Current Zoning: B-2(CD) (general business, conditional)
Proposed Zoning: B-2(CD) SPA (general business, conditional, site plan amendment)

Approximately 1.74 acres located on the west side of West W.T. Harris Boulevard, south of Mt. Holly-Huntersville Road, and west of Interstate 77.

The petition proposes to amend a previously approved rezoning plan (2017-182) to allow the previously approved carwash as a principle use in an alternate location on the site.

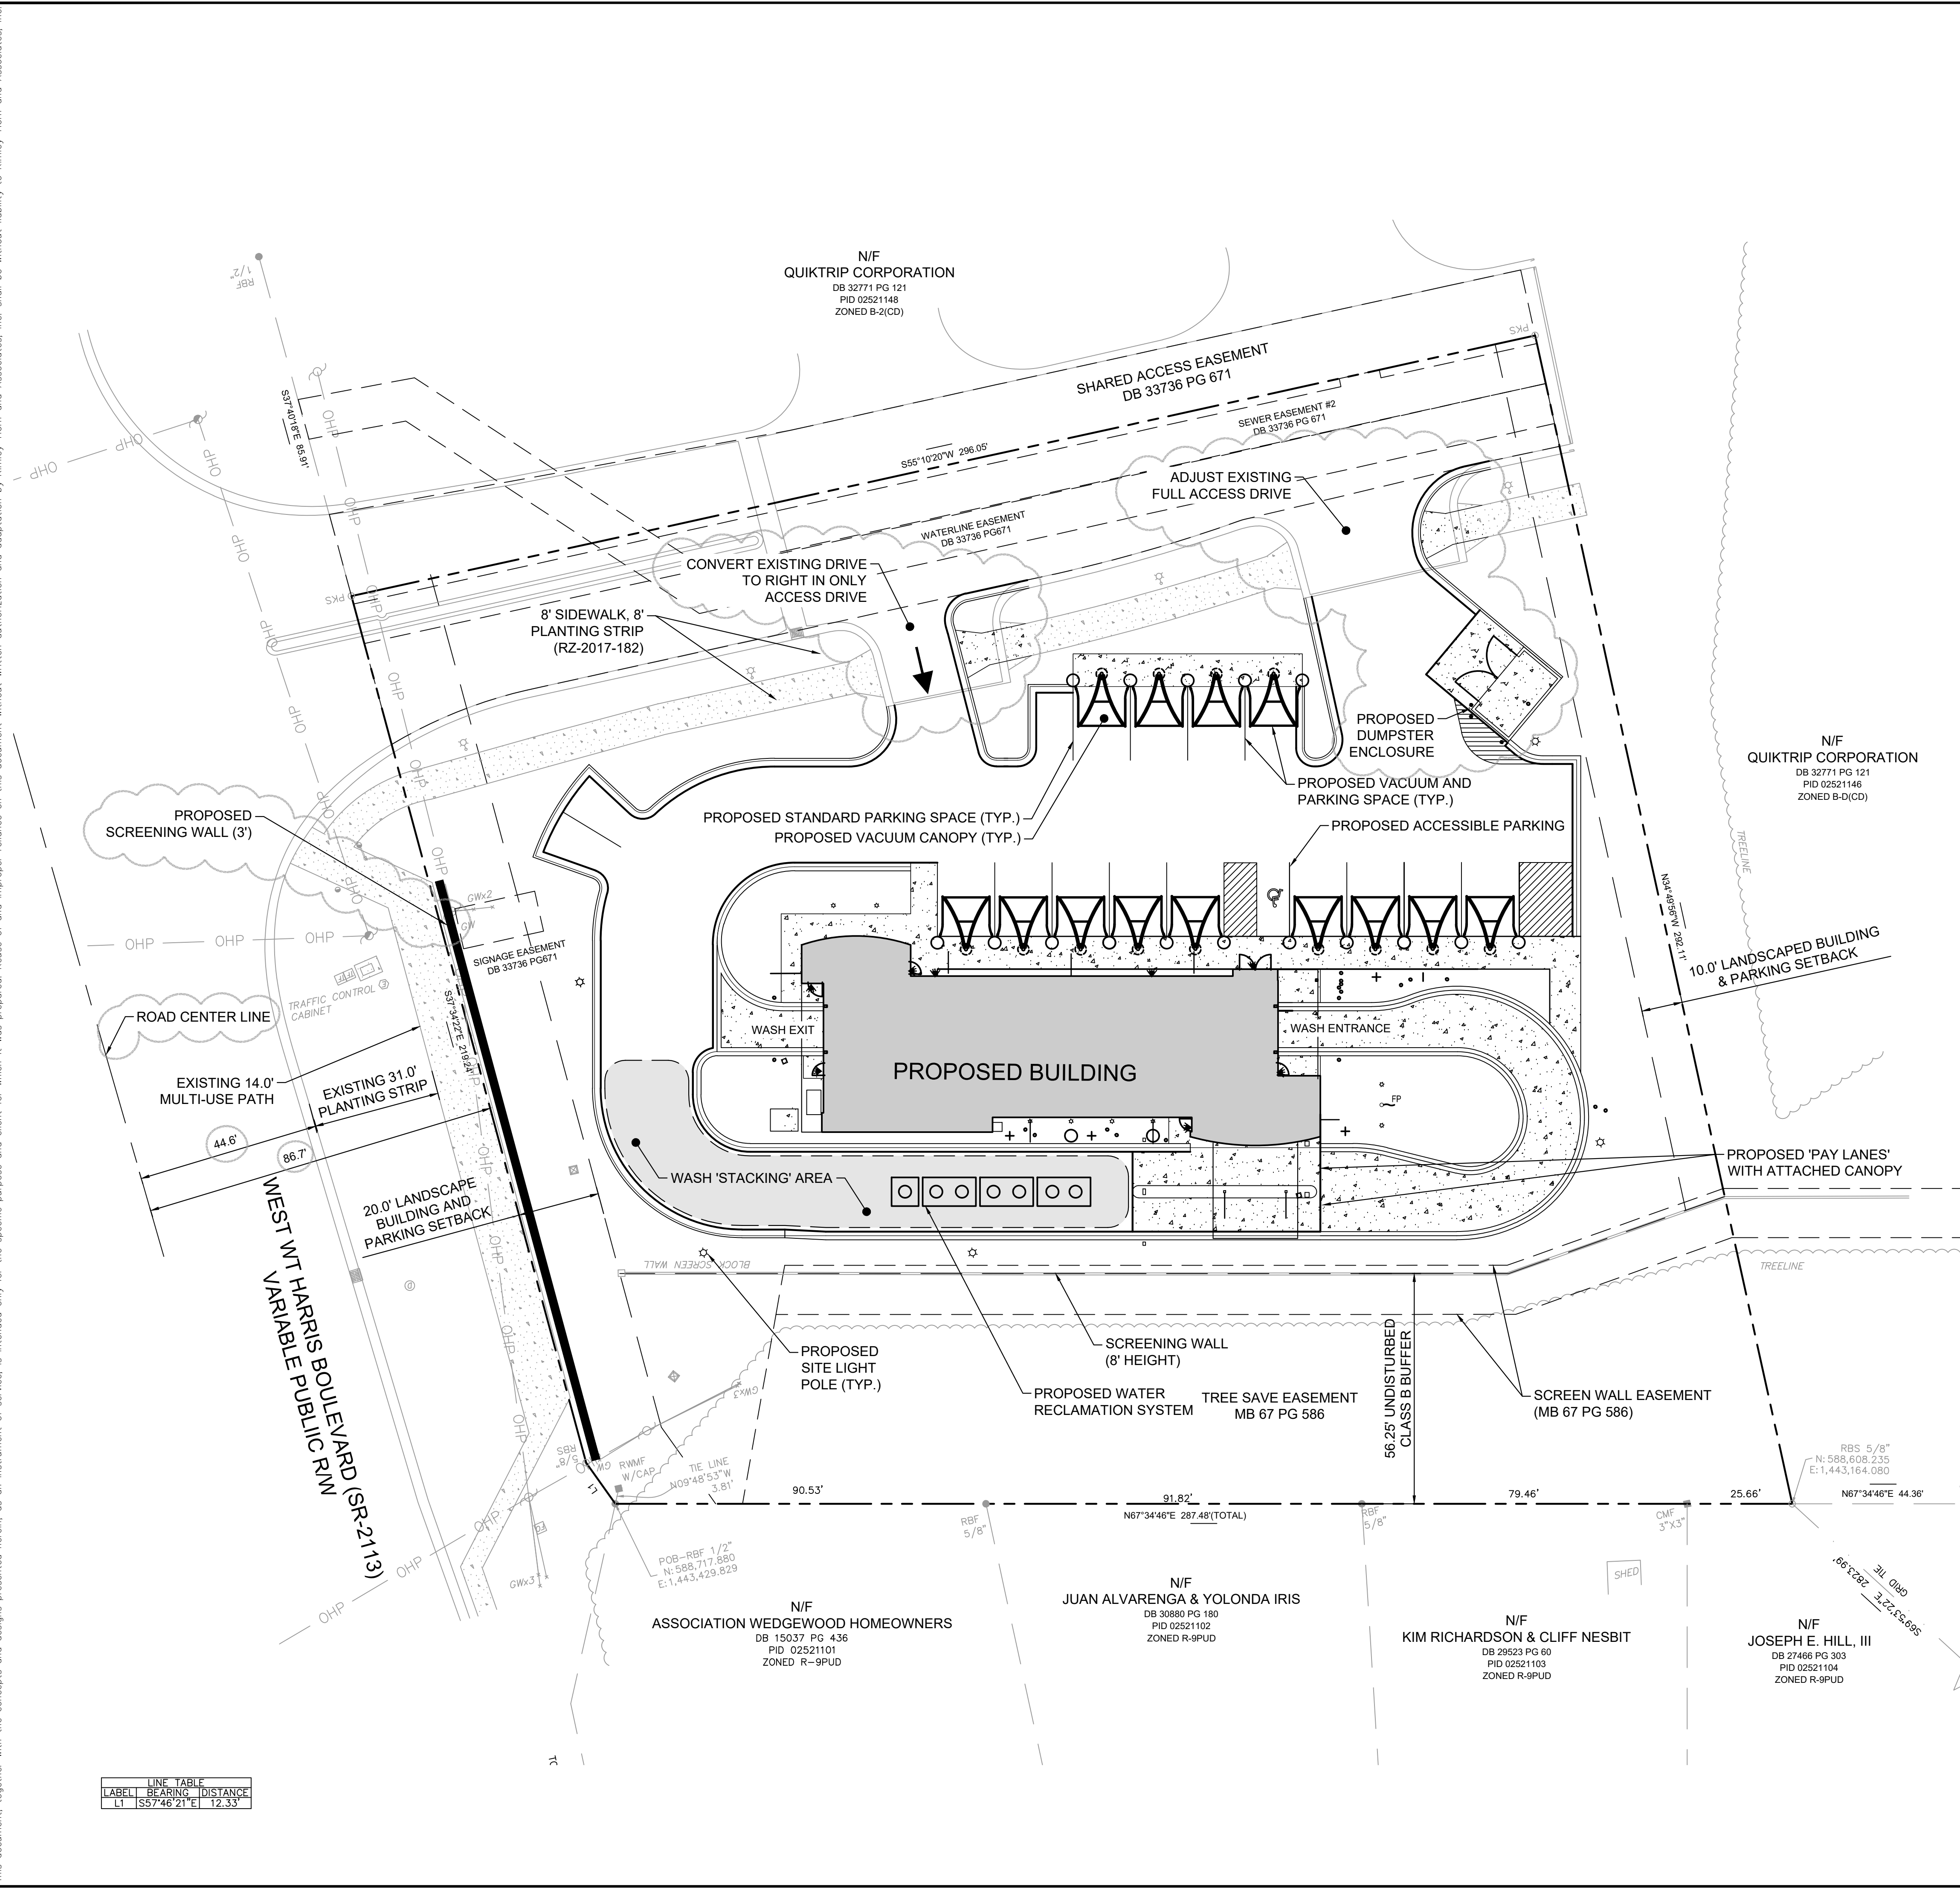
1. ~~Either remove the right in only driveway and keep the full access drive or keep the right in only access driveway and convert the full access drive to egress only. Revise conditional note 2f. to update this language to match the revised driveway design.~~ Addressed

2. ~~Revise the site plan and conditional note(s) to incorporate the minor conditional note corrections below.~~
Addressed

b. THE PLACEMENT AND CONFIGURATION OF THE VEHICULAR ACCESS POINTS ARE SUBJECT TO ANY ~~ADJUSTMENTS~~ **or NCDOT** SPECIFICATIONS REQUIRED TO ACCOMMODATE FINAL SITE DEVELOPMENT AND CONSTRUCTION PLANS AND TO ANY ADJUSTMENTS APPROVAL BY CDOT IN ACCORDANCE WITH APPLICABLE PUBLISHED STANDARDS.

c. THE ALIGNMENT OF THE INTERNAL VEHICULAR CIRCULATION AND DRIVEWAYS MAY BE MODIFIED BY THE PETITIONER TO ACCOMMODATE CHANGES IN TRAFFIC ~~CONDITIONS~~ **or NCDOT** STANDARDS, PARKING LAYOUTS AND ANY ADJUSTMENTS REQUIRED FOR APPROVAL BY CDOT IN ACCORDANCE WITH PUBLISHED STANDARDS.

d. THE PETITIONER WILL CONSTRUCT REQUIRED ROADWAY IMPROVEMENTS AND PROVIDE ANY REQUIRED SIDEWALK AND UTILITY EASEMENTS NEEDED FOR THESE IMPROVEMENTS PRIOR TO THE ISSUANCE OF THE FIRST CERTIFICATE OF OCCUPANCY, SUBJECT TO THE PETITIONER'S ABILITY TO REQUEST THAT CDOT ALLOW A BOND TO BE ~~FOR~~ **sidewalk utility easement** IMPROVEMENTS NOT FINALIZED AT THE TIME OF THE ISSUANCE OF THE CERTIFICATE OF OCCUPANCY, AS ALLOWED BY CDOT.

e. THE PETITIONER WILL DEDICATE VIA FEE SIMPLE CONVEYANCE ANY REQUIRED RIGHT-OF-WAY INDICATED ON THE REZONING PLAN AS RIGHT-OF-WAY TO BE DEDICATED. THE ADDITIONAL RIGHT-OF-WAY WILL BE DEDICATED PRIOR TO THE ISSUANCE OF THE FIRST CERTIFICATE OF OCCUPANCY. THE PETITIONER WILL PROVIDE A PERMANENT SIDEWALK EASEMENT FOR ANY OF THE PROPOSED SIDEWALKS LOCATED ALONG THE PUBLIC STREETS LOCATED OUTSIDE OF THE RIGHT-OF-WAY. THE PERMANENT SIDEWALK EASEMENT WILL BE LOCATED A MINIMUM OF TWO (2) FEET BEHIND THE SIDEWALK WHERE FEASIBLE.
